DRB Project Number: 2023-008778  
200 Tramway

SUBJECT: Sketch

### **Application For: PS-2023-00108-SKETCH PLAT (DFT)**

Project: Tract J-1-A & J-1-B, Four Hills  
Village Shopping Center &  
Apartment Complex Agenda Item No: 5

ISSUED FOR EPC - NOT FOR CONSTRUCTION		
ENGINEER'S SEAL RONALD R. BOHANNAN P.E. #7868	STARBUCKS ON TRAMWAY ALBUQUERQUE, NM GRADING & DRAINAGE PLAN 5571 MIDWAY PARK PLACE NE ALBUQUERQUE, NM 87109 (505) 858-3100 www.terrawestllc.com	DRAWN BY BF DATE 05/24/2023 2023047_GRE SHEET # C2 JOB # 2023047

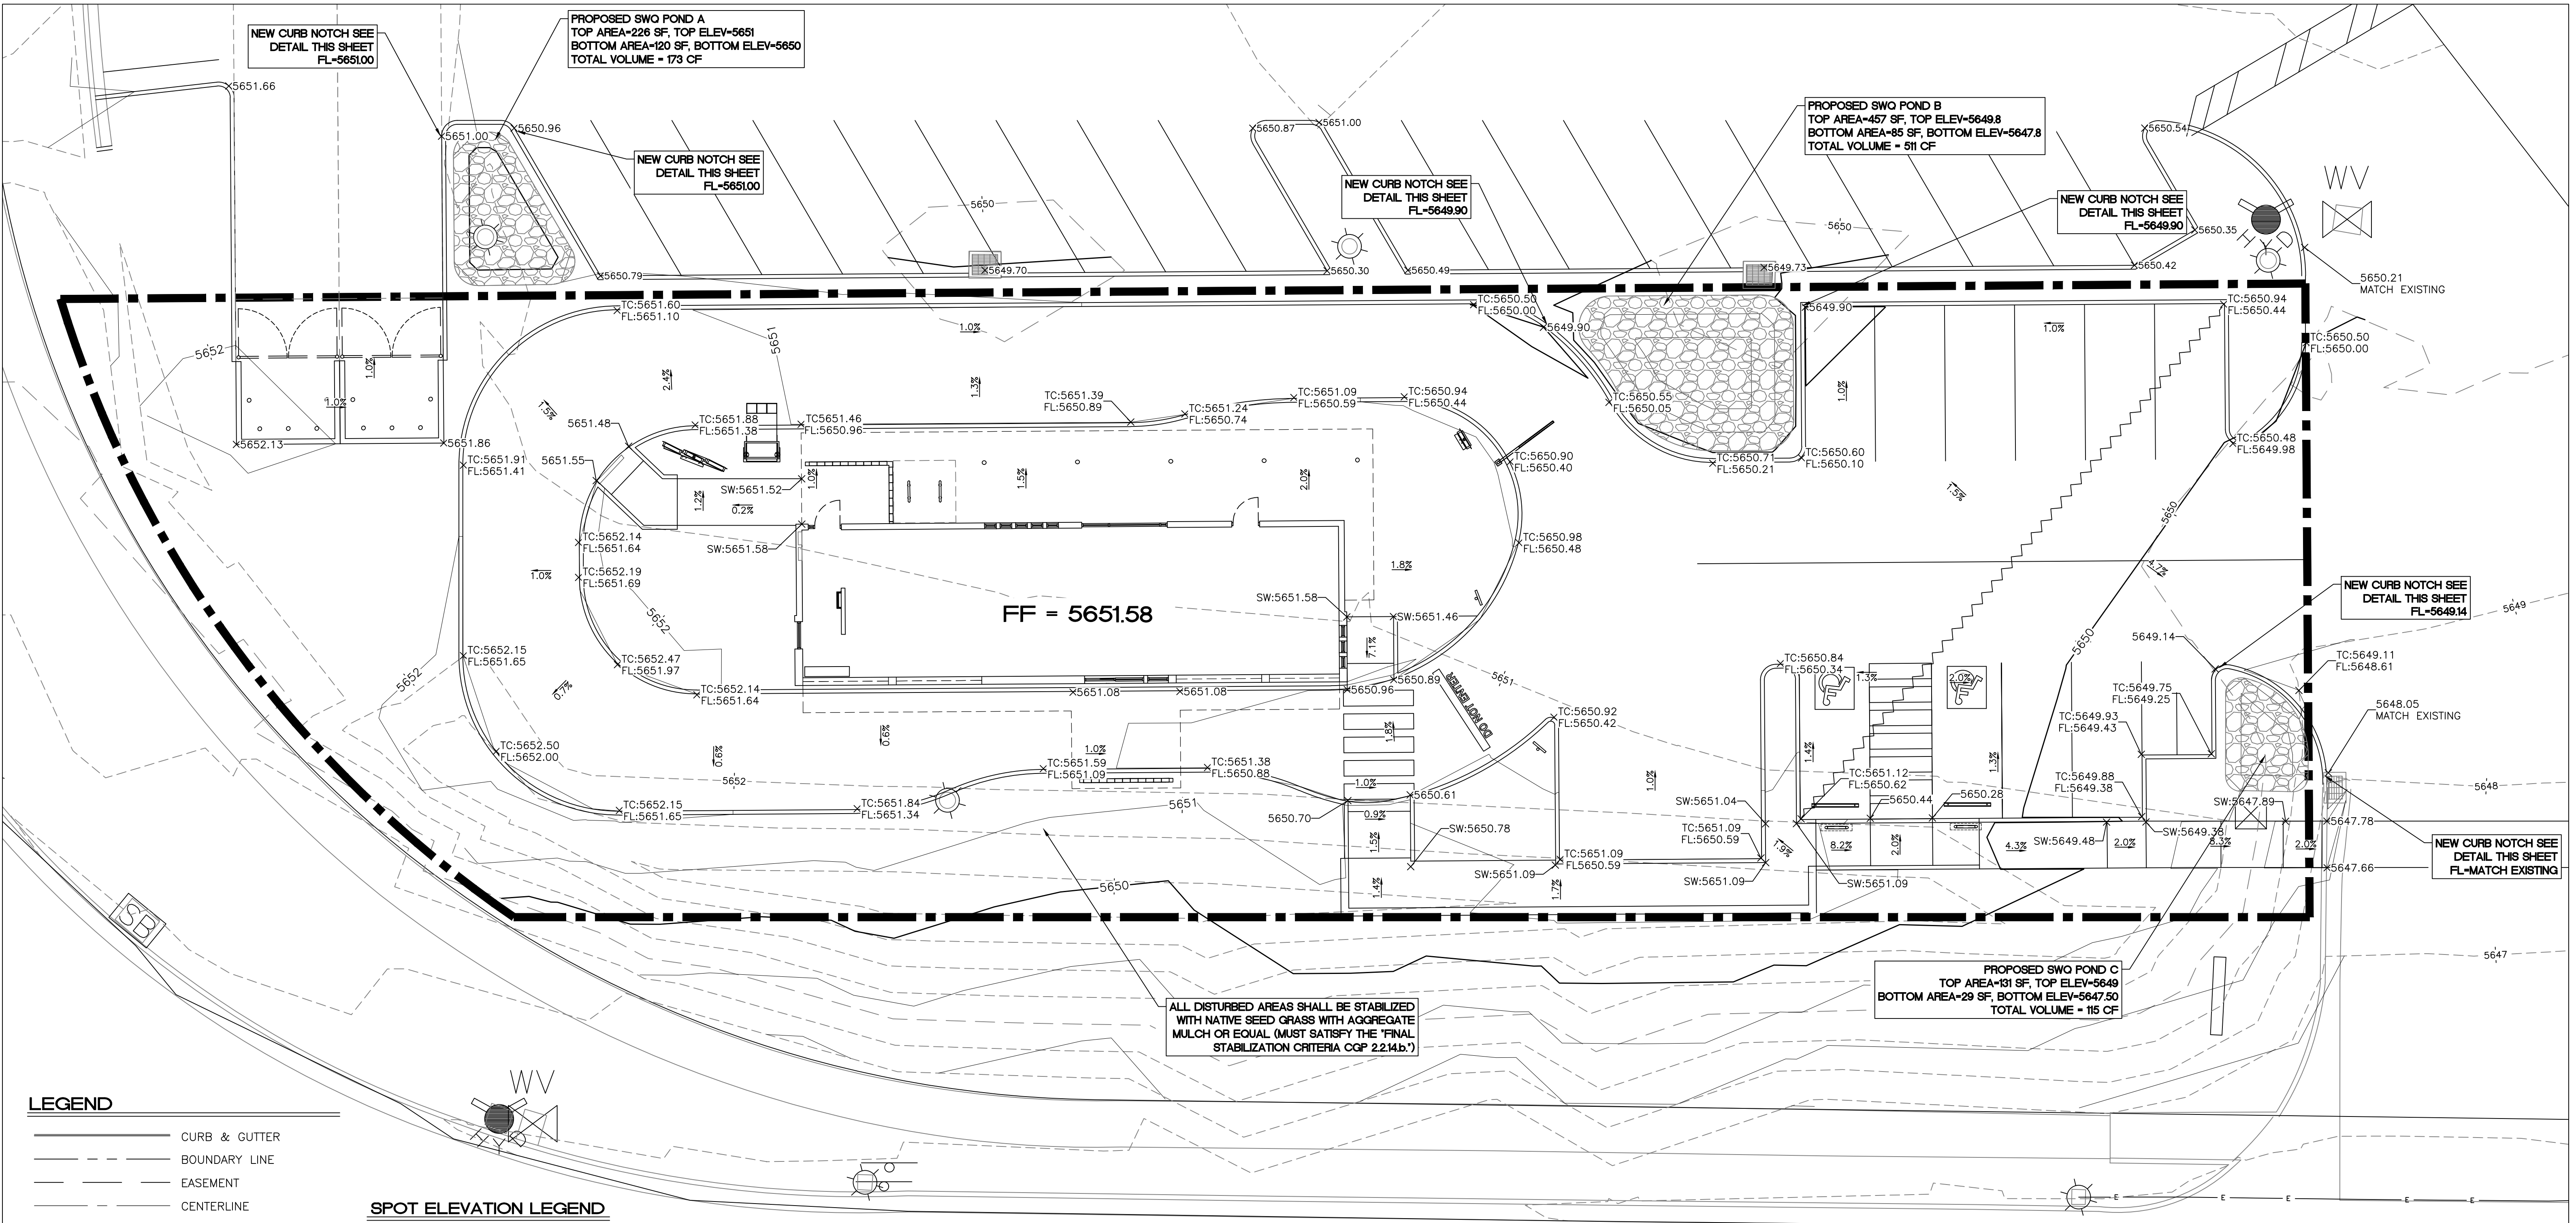
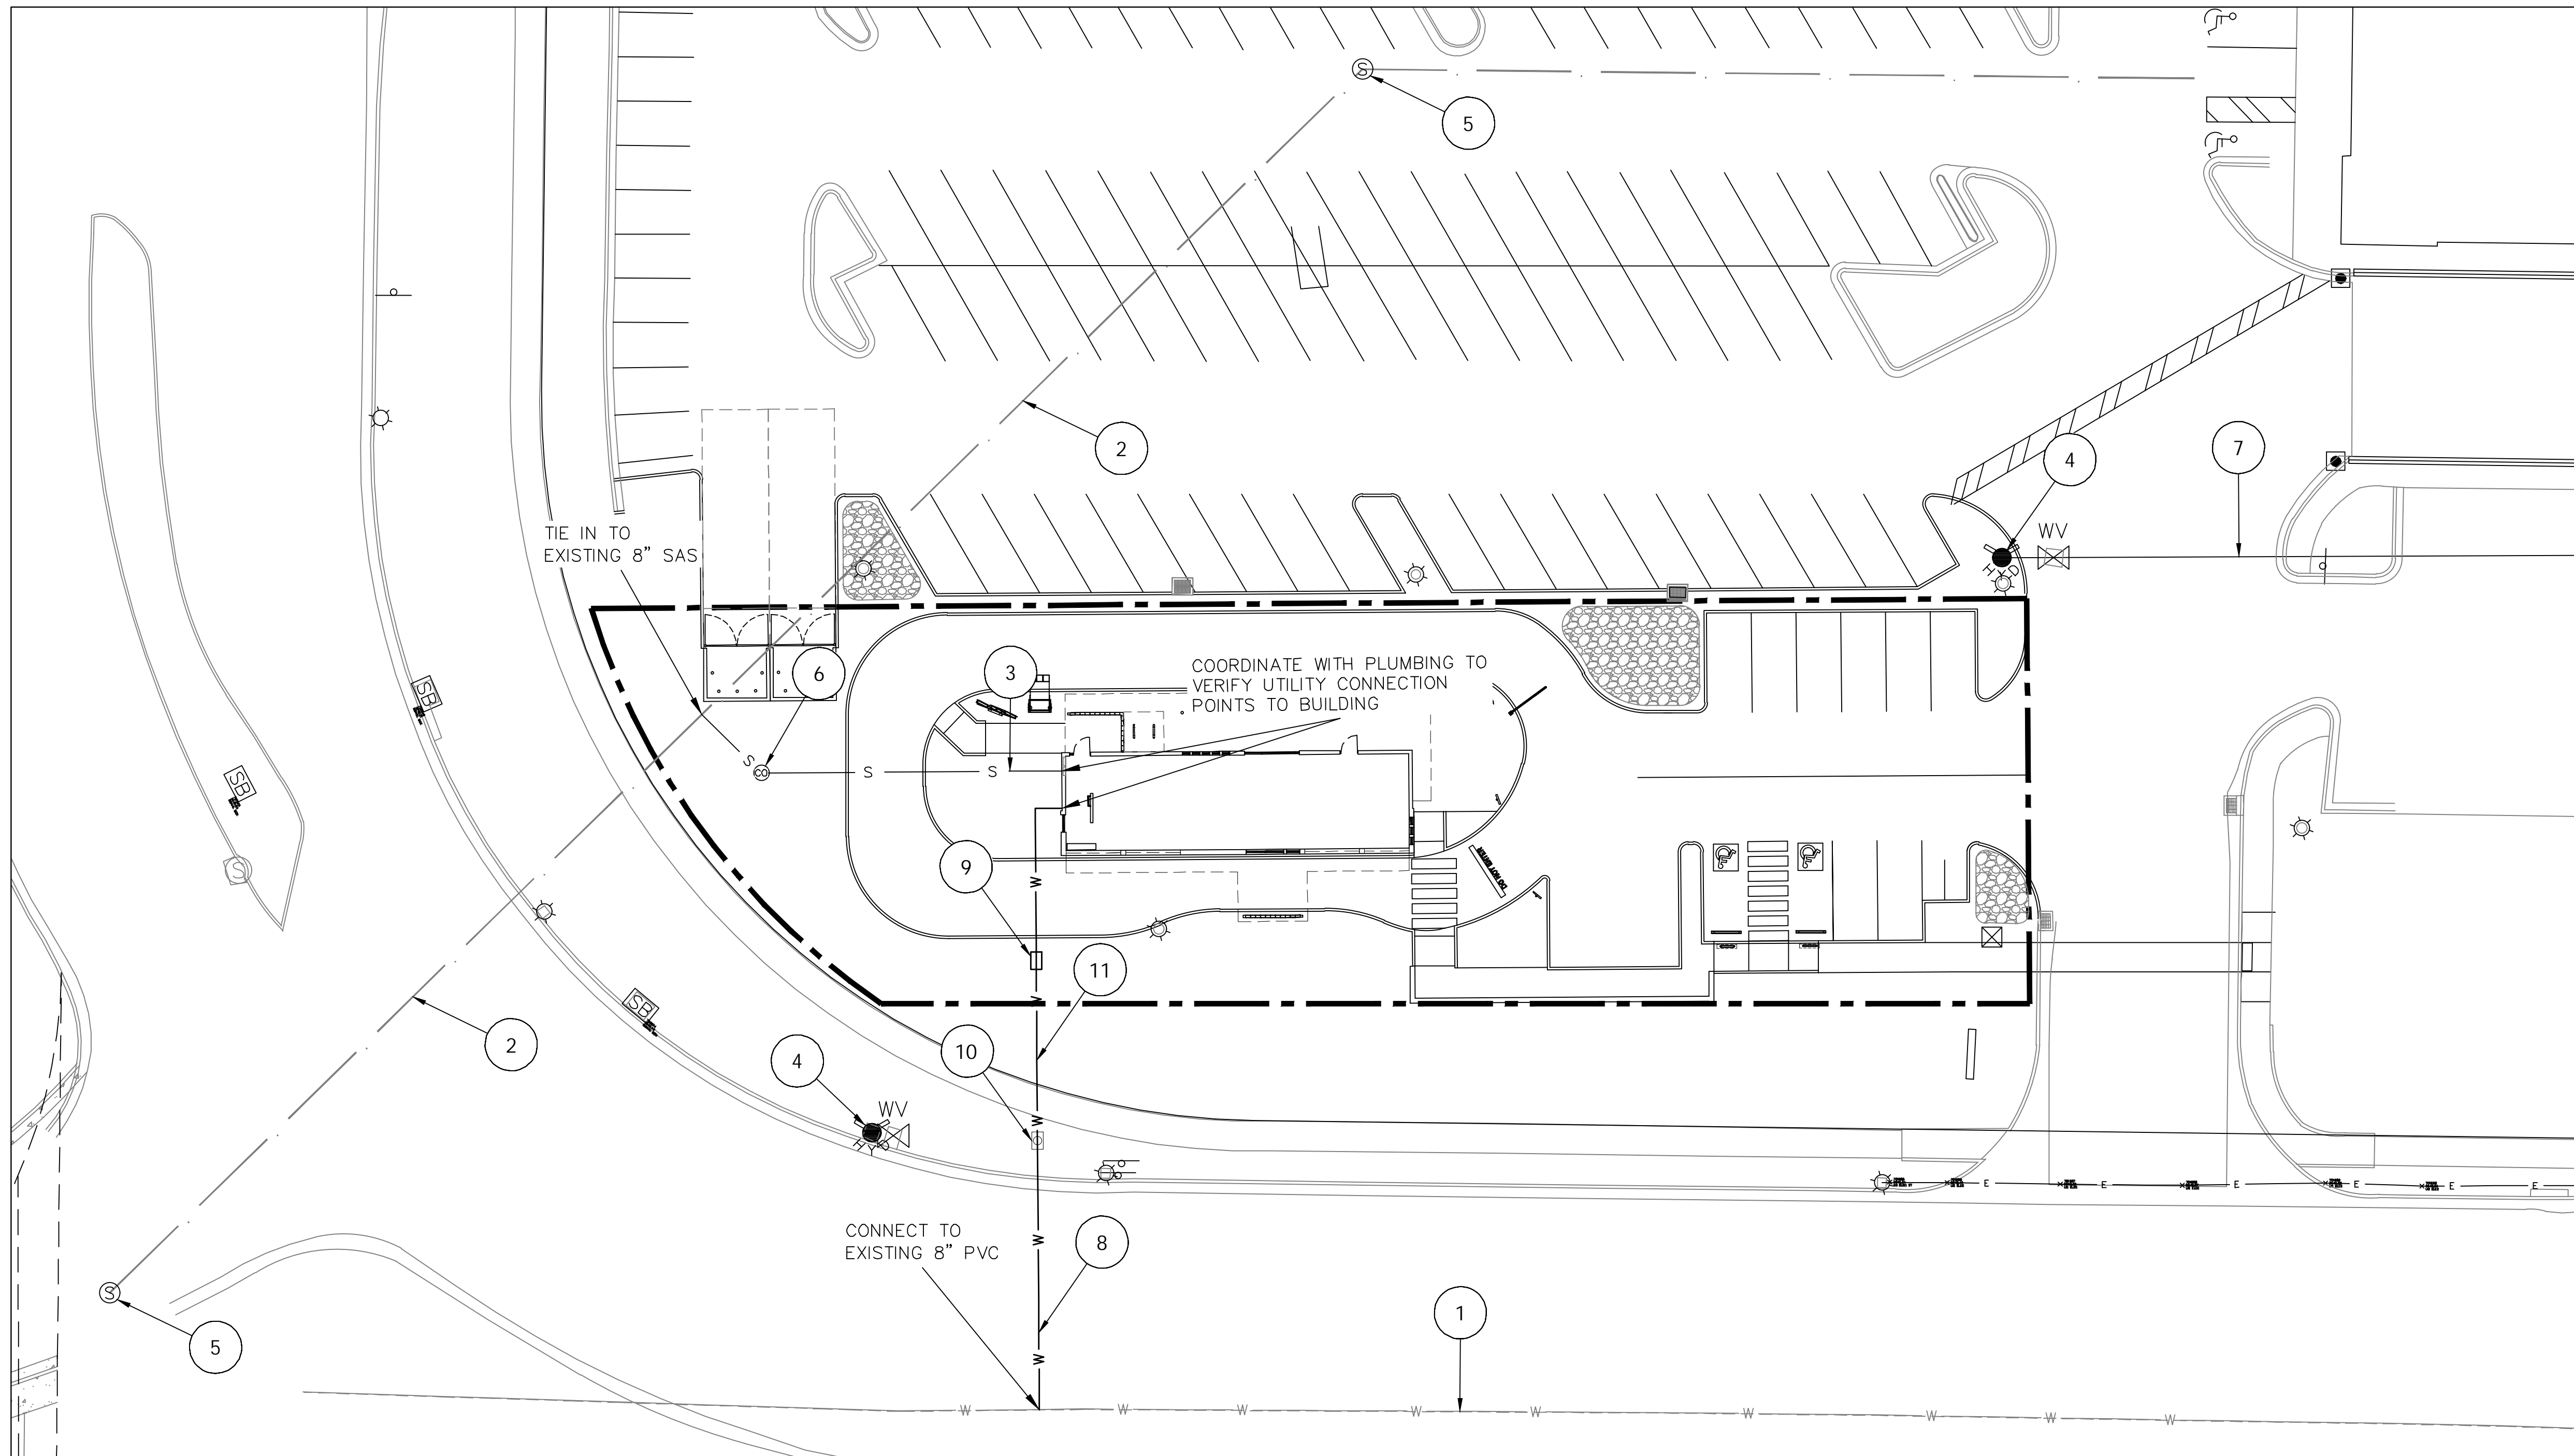
1. Availability Statement 230609 has been requested and will provide conditions for service.
2. The sanitary sewer shown on the existing site does not currently have any easements and records are not clear to the ownership of the line. This will be discussed in the provided statement and either easements may be required, or other requirements may be necessary for sanitary sewer service to be acquired.
3. The provided fire one plan shows the site utilizing a private hydrant on the adjacent proposed lot that houses the Smiths. This is not acceptable so the Starbucks will need to explore the potential use of an alternate fire hydrant. There is one at the NE corner of Tramway Blvd and Wenona Ave that appears to maybe be accessible to the site but will require updated approval from the Fire Marshall's Office.
